J.S. THOMPSON ENGINEERING, INC

May 8, 2023

A site visit was made to 159 Alice Holleman Lane in Fuquay-Varina, North Carolina to inspect and analyze the bottom of the over-excavated footings.

Component Inspected: Crawl space footings

DESCRIPTION:
FOUNDATION PLAN

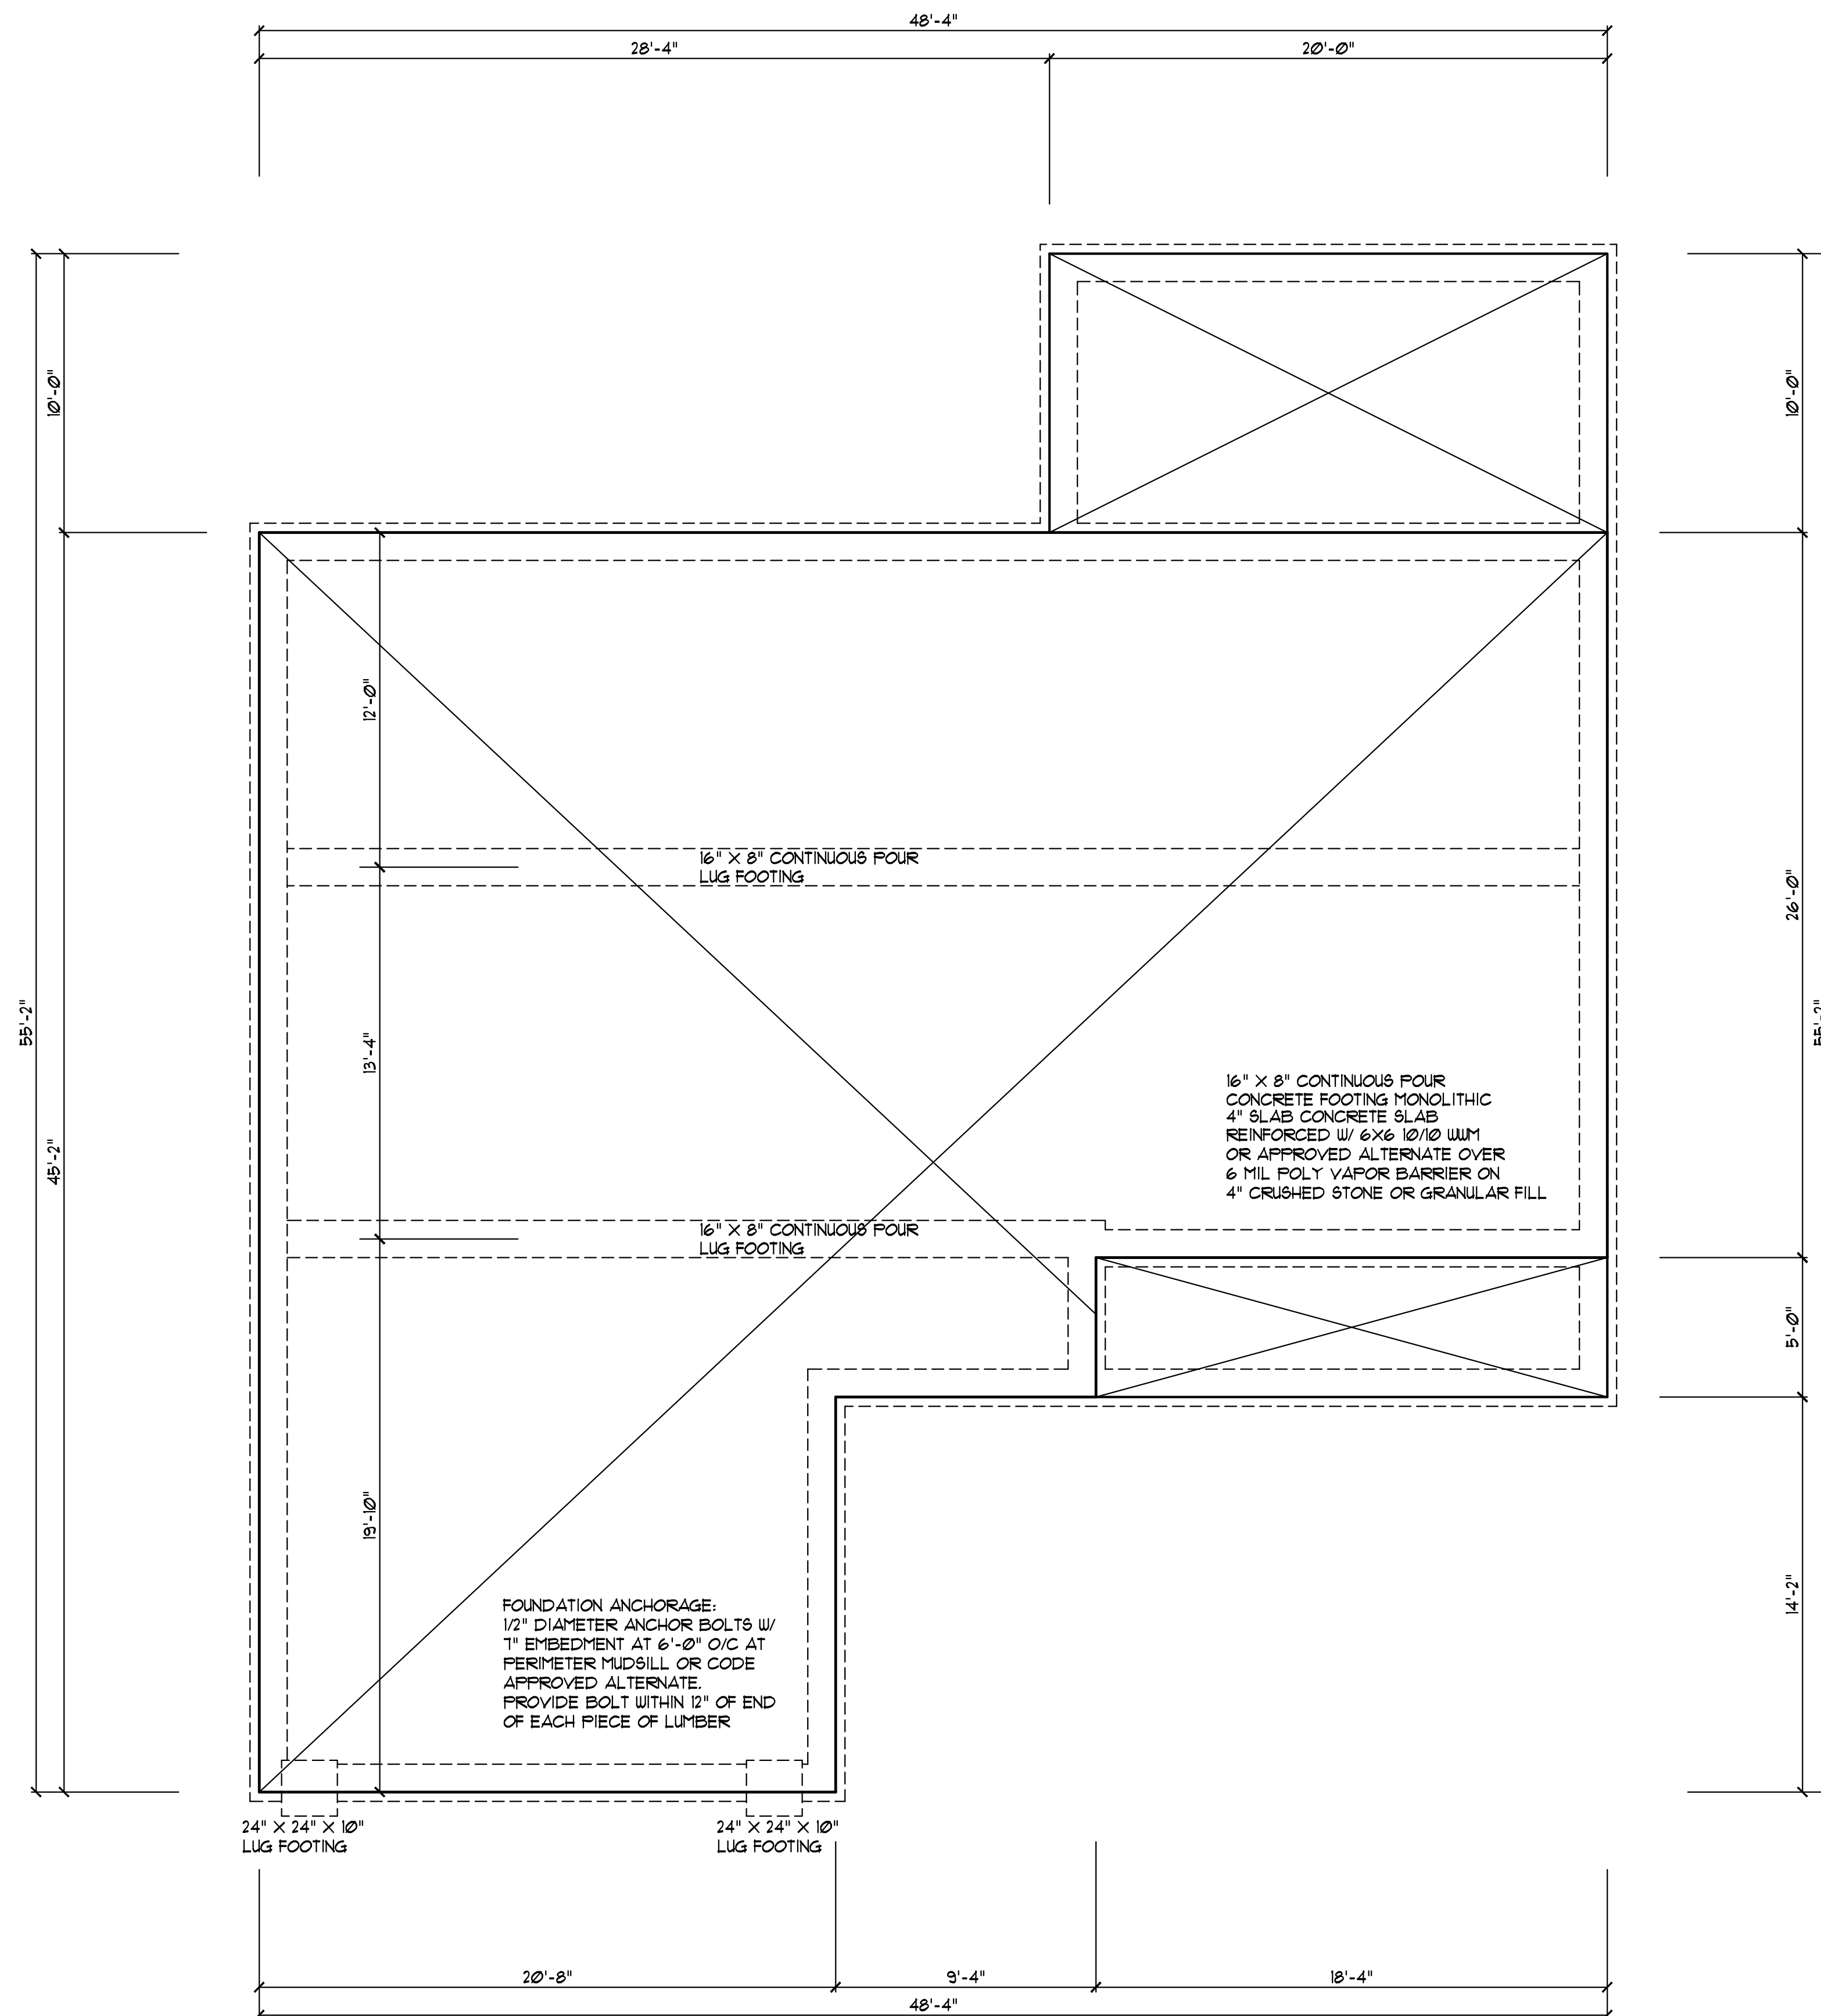
The bottom of the footings was inspected and firm residual silty clay was encountered at depths ranging from two to four feet below grade. The over-excavated footings were backfilled with washed stone per my direction. The soil at the bottom of the footings will provide the minimum required bearing capacity of two thousand pounds per square foot.

Third party inspection revealed three deviations. The plan specified rebar is not necessary and was omitted per my direction. The continuous wall footing concrete depth was set at 8" per my direction in lieu of 10" per plan for the one-story single-family structure. Five 24" x 24" x 8" pier footings were excavated for the rear porch per my direction in lieu of the plan specified continuous wall footing. The porch floor system is to be framed with treated 2 x 8 SYP #2 floor joists spaced 16" o.c. spanning front to back. Treated (2) 2 x 10 SYP #2 beams are to be installed at the exterior sides of the porch floor system. The rear porch beam is to be supported by treated 6 x 6 SYP #2 posts spaced +/- 5'-0" o.c. installed to bear on the pier footings. The rear porch floor system is to be constructed in accordance with Appendix M – Wood Decks of the 2018 North Carolina Residential Code. Besides the deviations noted above, the remainder of the footings were excavated per the approved plan with all concrete depths and step downs set correctly. The footings are in conformance with Chapter 4 of the 2018 North Carolina Residential Code and are suitable for concrete placement.
